# Rezoning Transportation Analysis

Petition Number: 2022-121

Date	Description
01-25-23	First Review (PDM)
02-22-23	Second Review (JP)
07-18-23	Third Review (DR)
8-23-2023	Fourth Review (PDM)

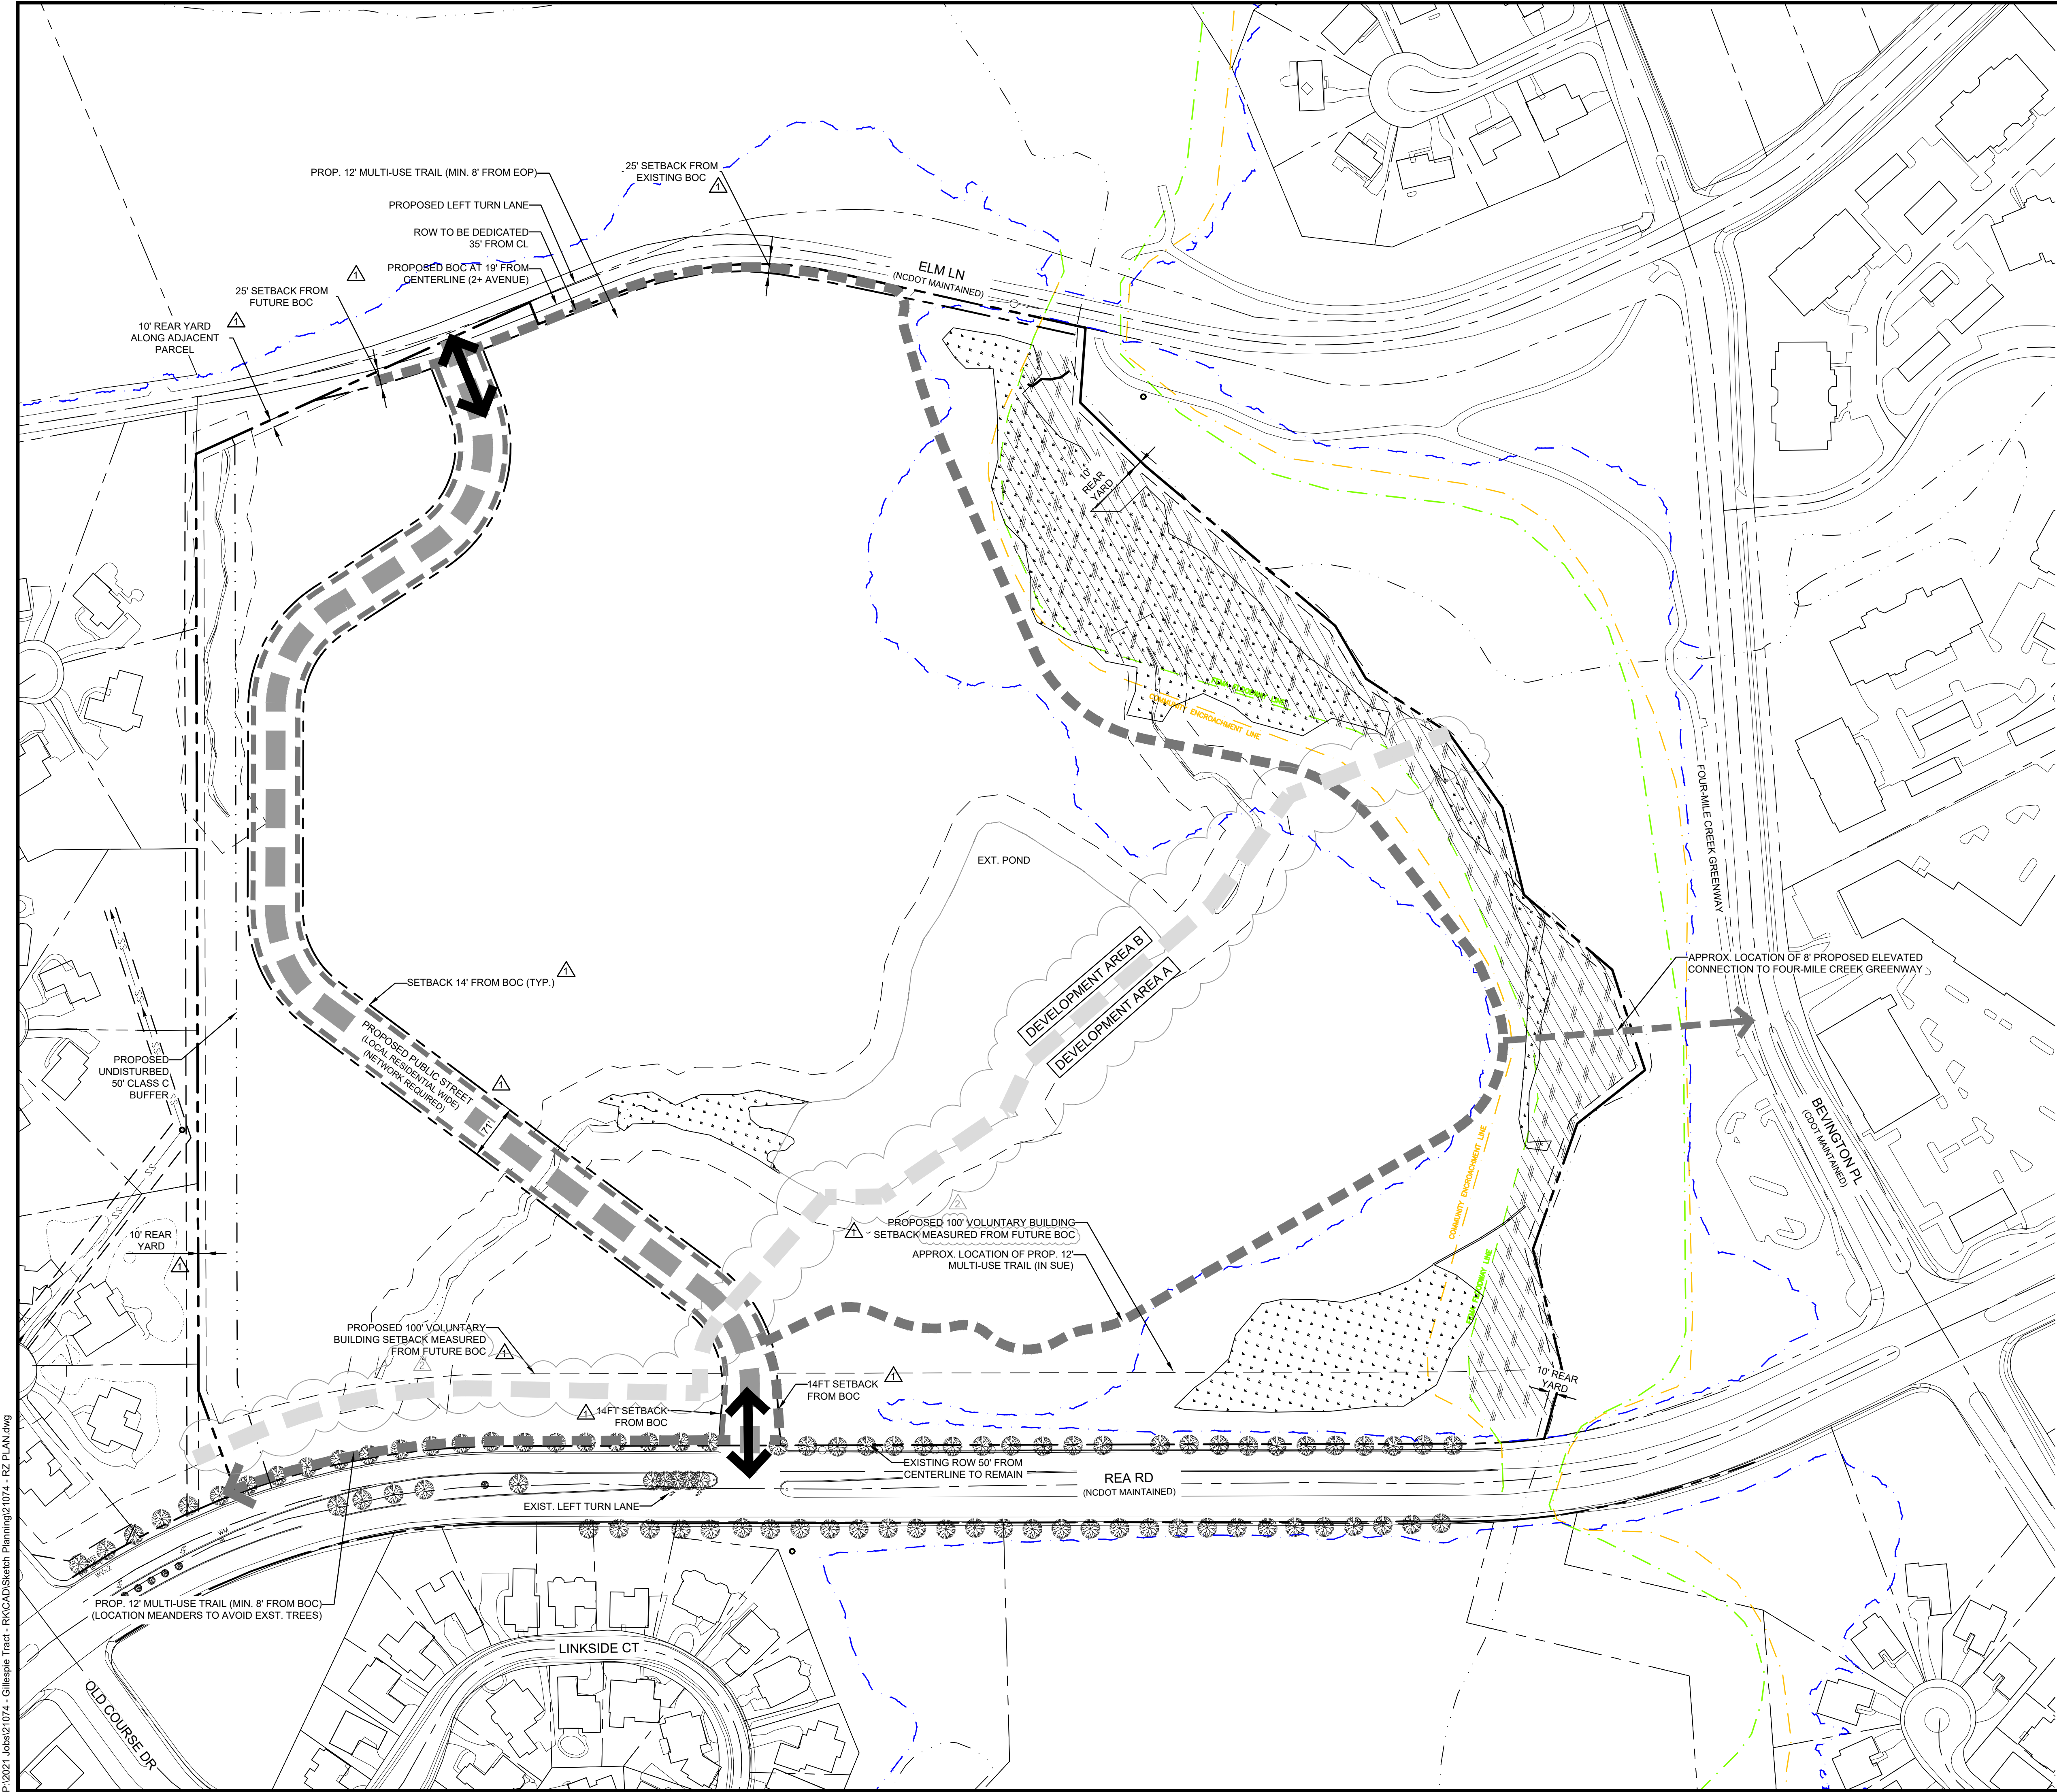
**Update Comment from 8/23/2023:** MUP needs to follow Rea Road for a greater distance. Engineering documentation needs to be provided to allow the required streetscape (MUP) to be constructed onsite.

9. **New Comment 2-22-23:** Revise site plan and conditional note(s) to install curb and gutter along the site's frontage on Elm Lane. Back of curb to be installed at 27' from the centerline along Elm Lane as described in the Charlotte Streets Map.
10. **New Comment 8-23-23:** Revise conditional notes for MUP to be completed prior to the first building CO.

11. **New Comment 8-23-23:** Remove conditional note.

12. **New Comment 8-23-23:** Revise notes to match phasing outlined in traffic study. Improvements to be completed prior to first CO for the site.
